Please ask for: Ms Iqraa Malik
Email: iqraa.malik@terraquest.co.uk
Telephone: 01212341390
Our Ref: LU/223/21/HH
Your Ref:
Date: 27th July 2021

Application for Planning Permission for Works or Extension to a Dwelling

Development: Realign garden boundary wall approximately one meter offset from existing.
Location: 25 Davits Drive Littlehampton BN17 6RU

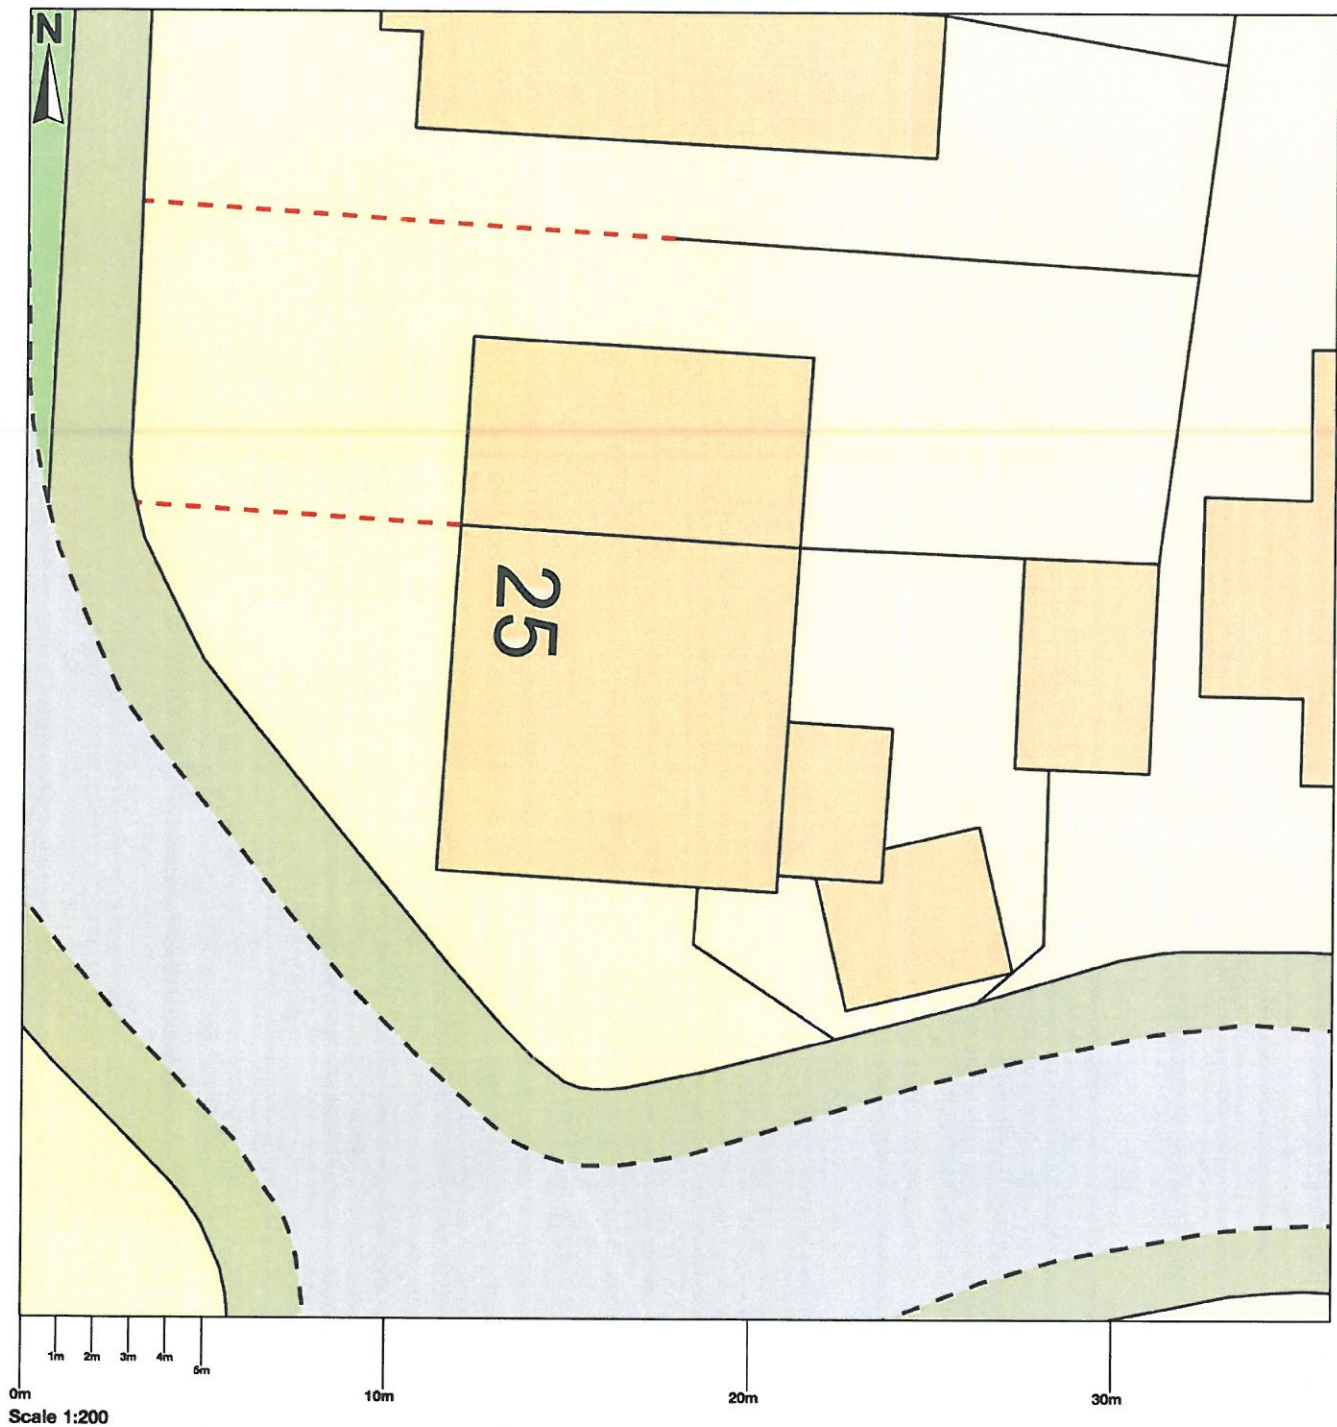
Please add a stated scale and scale bar to the site plan

Map shows area bounded by: 504048.28,102617.29,504189.72,102758.71 (at a scale of 1:1250) The representation of a road, track or path is no evidence of a right of way. The representation of features as lines is no evidence of a property boundary.

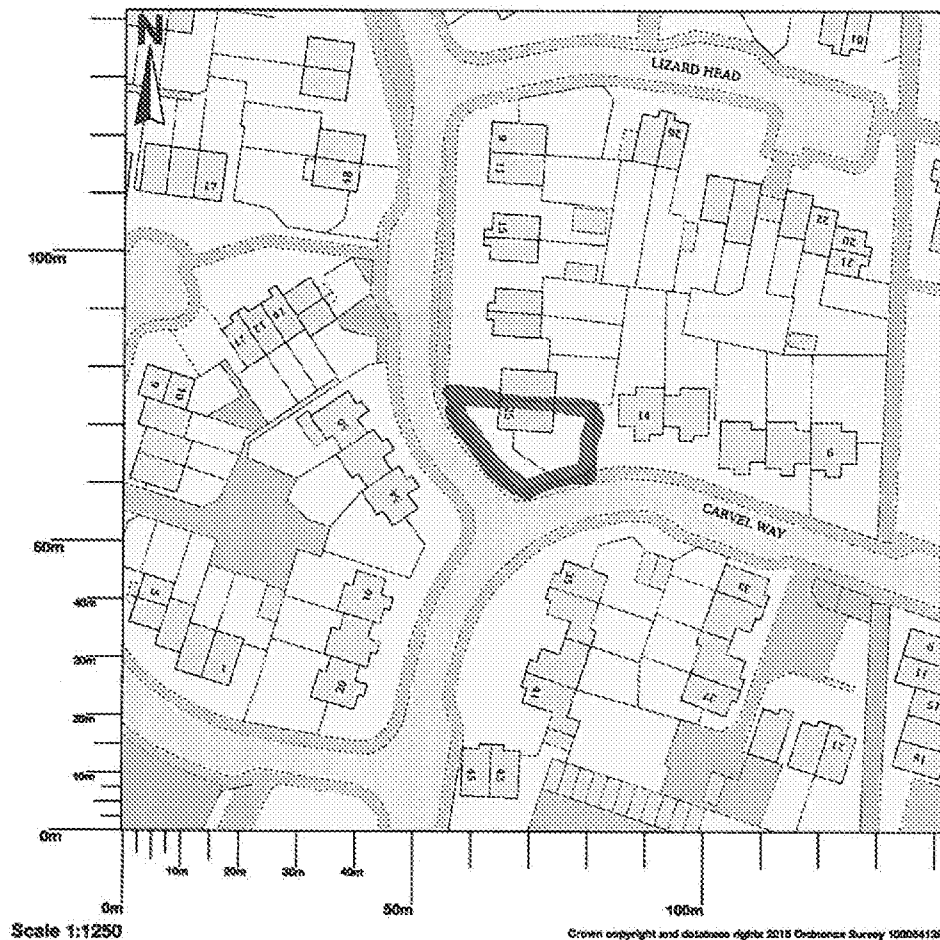
Please amend the location plan to include a solid red outline around the site address boundary. Further details of what must be included on the plan can be found in the Validation Requirements List.
